Morgan Offshore Windfarm Generation Assets Case Team
Planning Inspectorate
morganoffshorewindproject@planninginspectorate.gov.uk
(Email only)

MMO Reference: DCO/2022/00003
Planning Inspectorate Reference: EN010136
Identification Number: 20048964

Planning Act 2008, BP Alternative Energy Investments Ltd, Proposed Morgan Offshore Windfarm Generation Assets Order

Deadline 2 Submission

Figure 3.1: Herring spawning grounds with subsea sound contours for a 5.5 m diameter pile (Menck, 4,400 kJ, SELss).

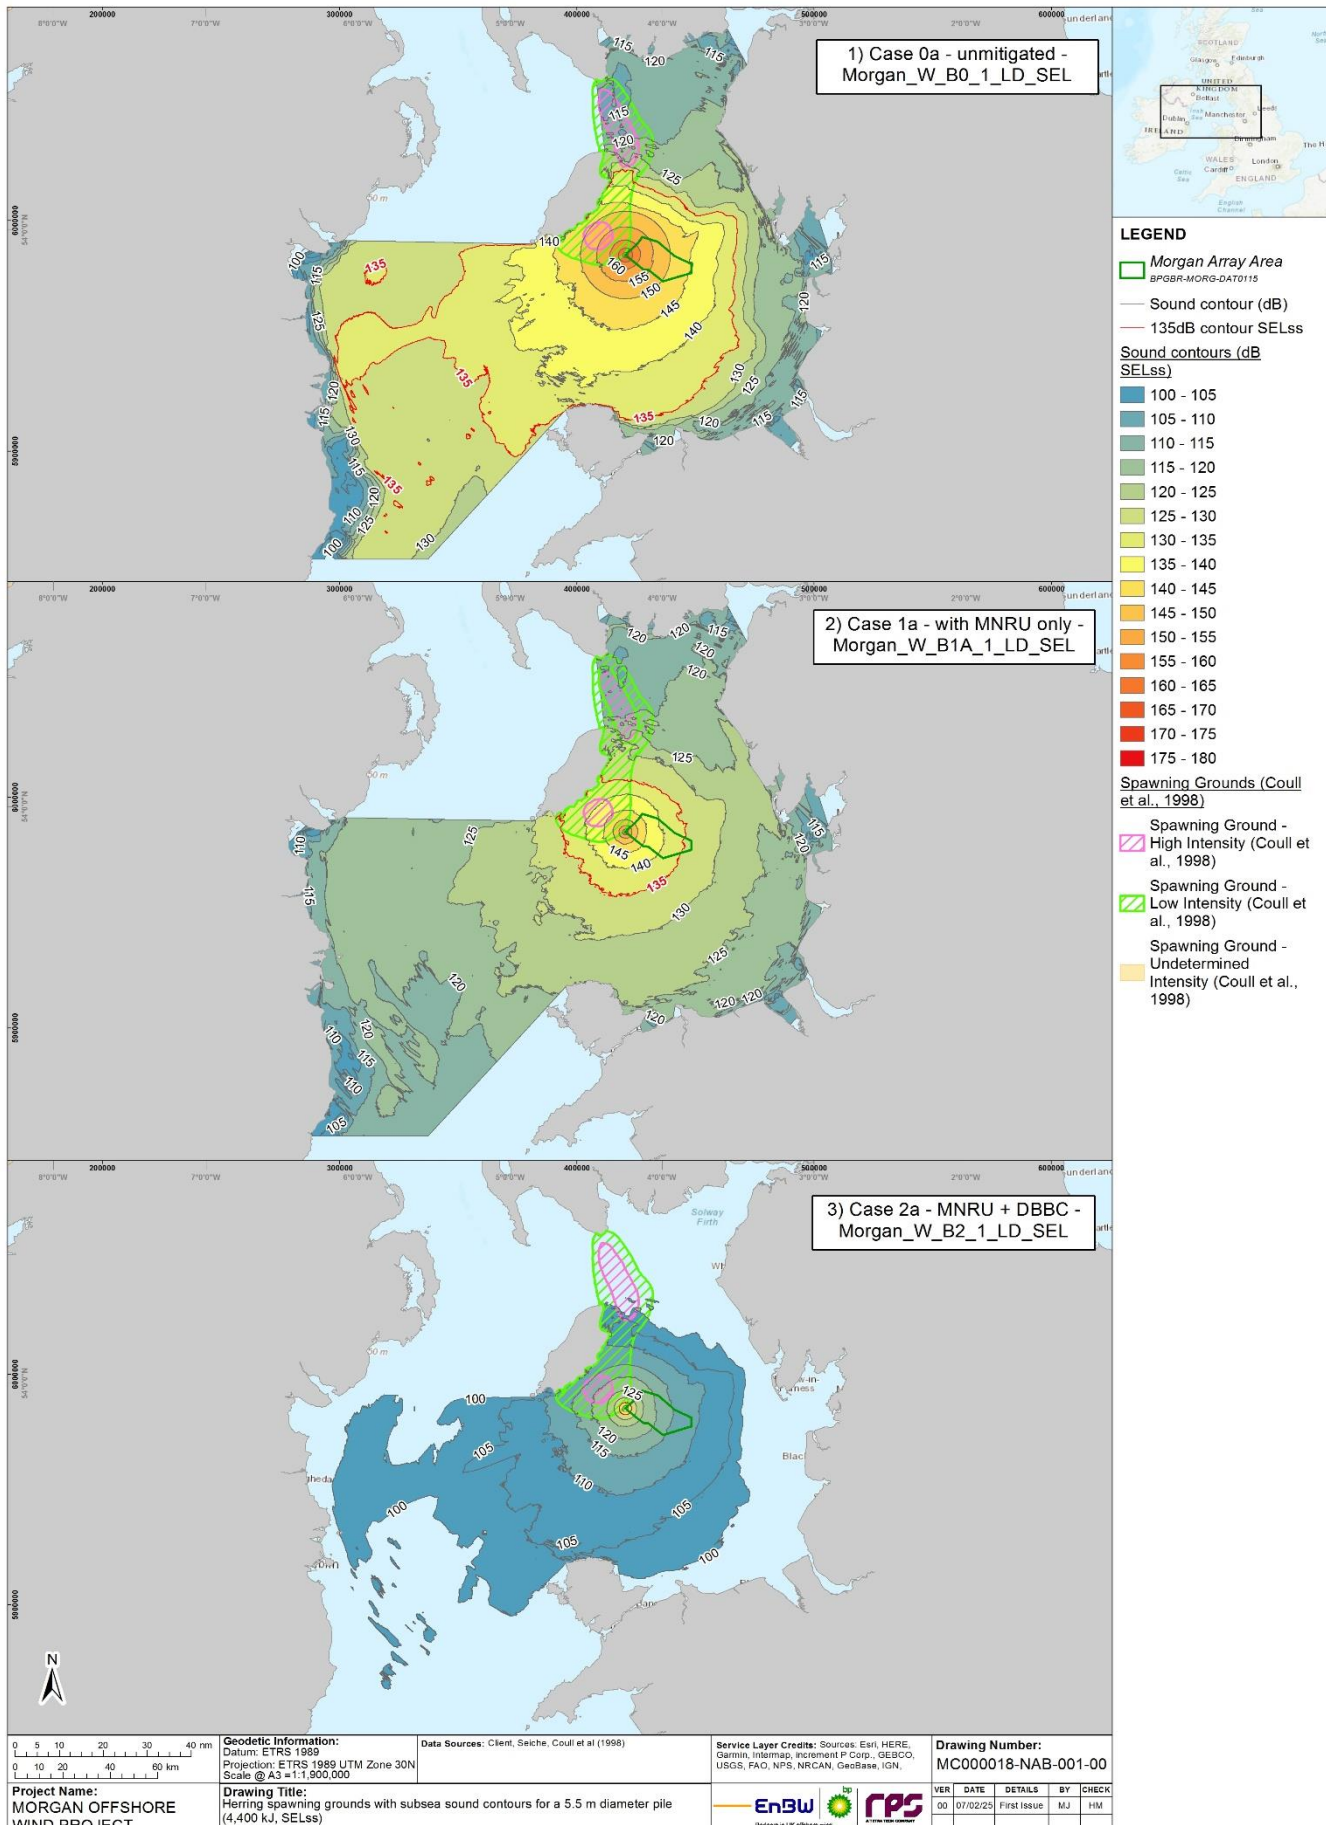
1.3.3. In relation to Section 1.2.2 and 1.2.3 of Annex 3.3 regarding herring; the MMO thanks the Applicant for restating that the assessment of behavioural effects to herring in response to UWN from piling is underpinned by the use of a sound level of 135 dB re $1\mu\text{Pa}^2 \cdot \text{s}$ SELss, as per Hawkins et al., (2014). The MMO notes the Applicant's objections to using the 135 dB threshold of Hawkins et al., (2014), but given an absence of other peer-reviewed empirical evidence of behavioural responses in clupeid fishes to support an alternative threshold for impulsive noise, Hawkins et al., (2014) is still considered the best available scientific evidence by the MMO. Please see MMO response RR-020.56 in Table 1 as to why the studies by Doksaeter et al., (2012) and McCauley et al., (2000) are not suitable for the purpose of defining a threshold for modelling behavioural responses in Atlantic herring at their spawning grounds. The MMO further thanks the Applicant for recognising that the 135 dB threshold of Hawkins et al., (2014) is the more precautionary of the two proposed thresholds. The MMO notes clarified UWN modelling maps for behavioural responses in herring relative to the Isle of Man herring spawning ground, for single piling with a 4,400 kJ hammer energy and with a 3,000 kJ hammer energy.
